**Re: Lead Avenue Townhomes
Grading and Drainage Plan
Engineer's Date 12-1-14 (K15D094)**

Based upon the information provided in your submittal received 12-2-14, the above referenced plan is not approved for Building Permit. Please address the following comments:

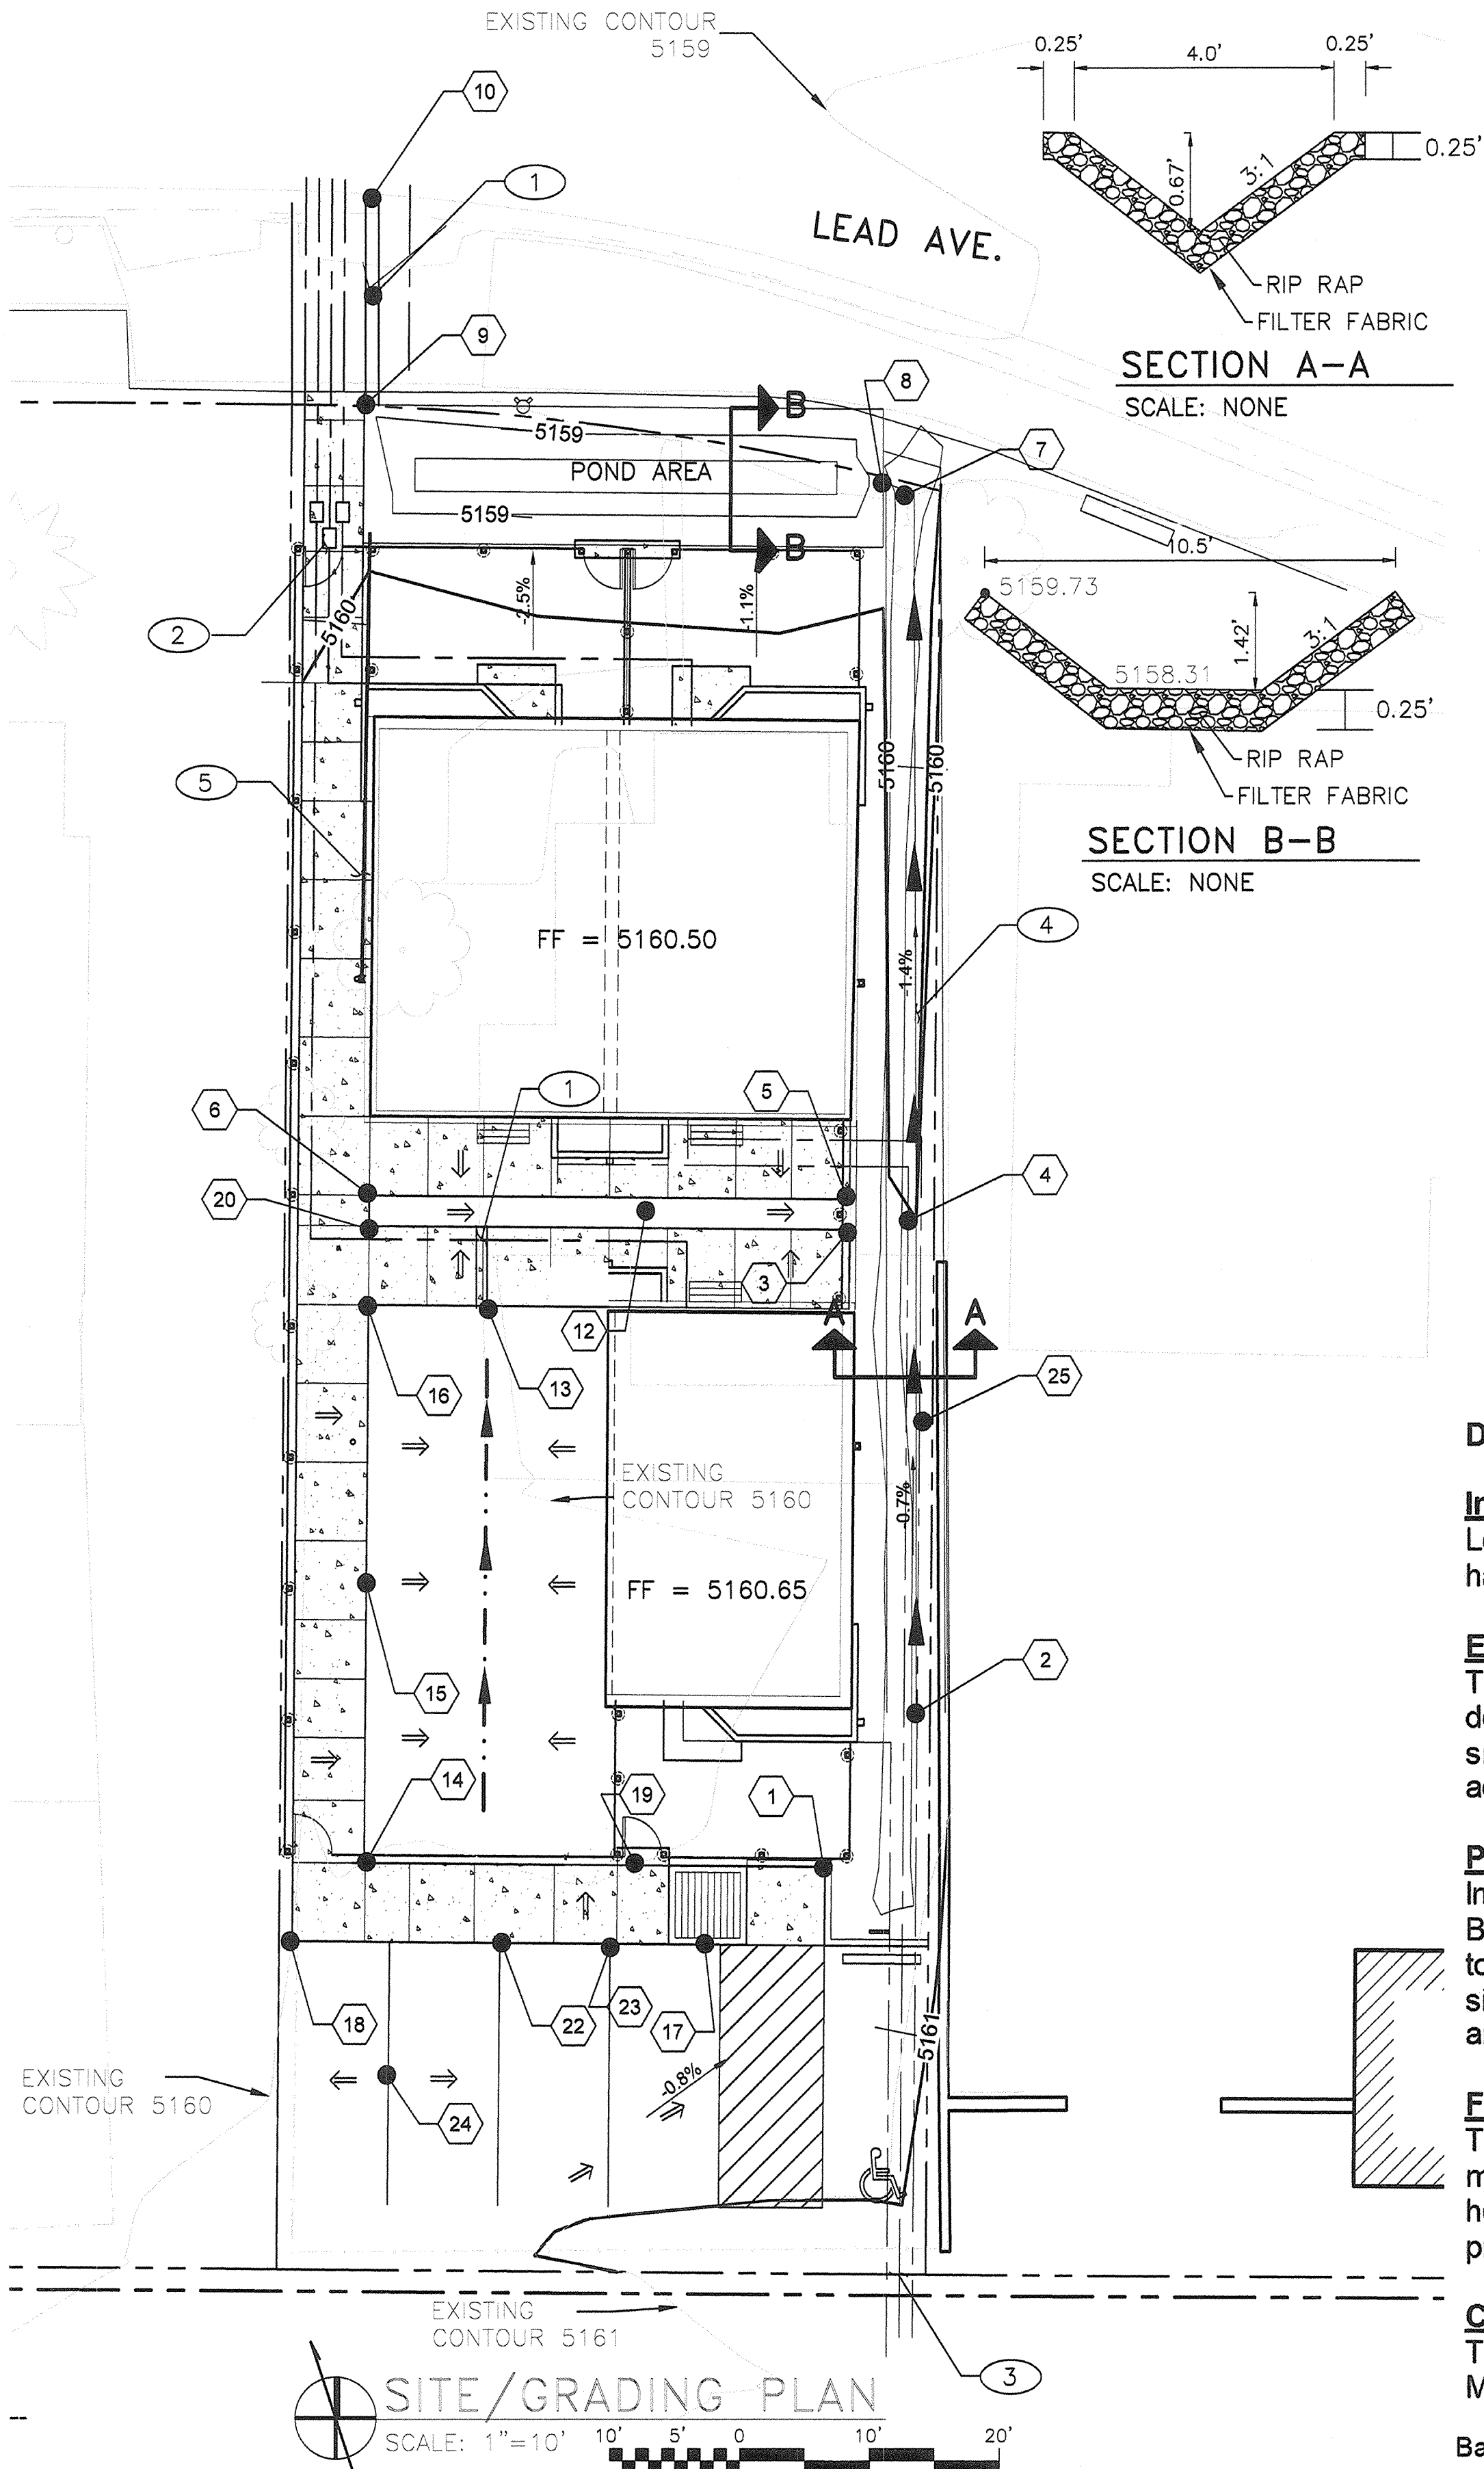
1. The proposed impervious area is 60%. The impervious area in the plan view is greater than that (approximately 75%). Please revise.
2. What is the height of the water in the swale? At the shallowest point next to the southern building, the swale has 0.08 feet of clearance between the invert and the Finished Floor of the building. The water surface elevation should be below the Finished Floor. In Keyed Note 4, the swale has a height of 0.0 feet to 0.75 feet. The minimum height of the swale should be at the water surface elevation. Will the water between the buildings be able to get into the swale? Provide more spot elevations to show how the water will drain.

3. Is the sidewalk on the southern end of the buildings flush with the asphalt or raised above the asphalt? The sidewalk is at 60.82, but the Finished Floor is at 60.75. The sidewalk should be sloping away from the building. The site historically flowed north. What are the elevations that the site is matching in the alley? How is the storm water going to drain north from the parking lot without going onto adjacent properties? How is the water being directed to the swale? Show more spot elevations. (Please note that it is highly unusual to give a northing and easting for the spot elevations. Simply place the elevations on the plan where needed.)

4. The difference between existing and proposed flows is not being detained. Why is that?
5. State the volume that is being provided for the First Flush. That volume should be a retention portion of the pond that is below the invert out elevation. Provide top and bottom of pond elevations on the plan in addition to the invert out elevation.

6. The area near the drain lines through curb is identified as a "no work area" on the plans. Please remove since the drain line work will need to be done with these plans as part of the SO-19.

7. Provide a legend for the line work. Some existing contour lines are not labeled. Please label. Tie in the proposed 61 contour with existing.
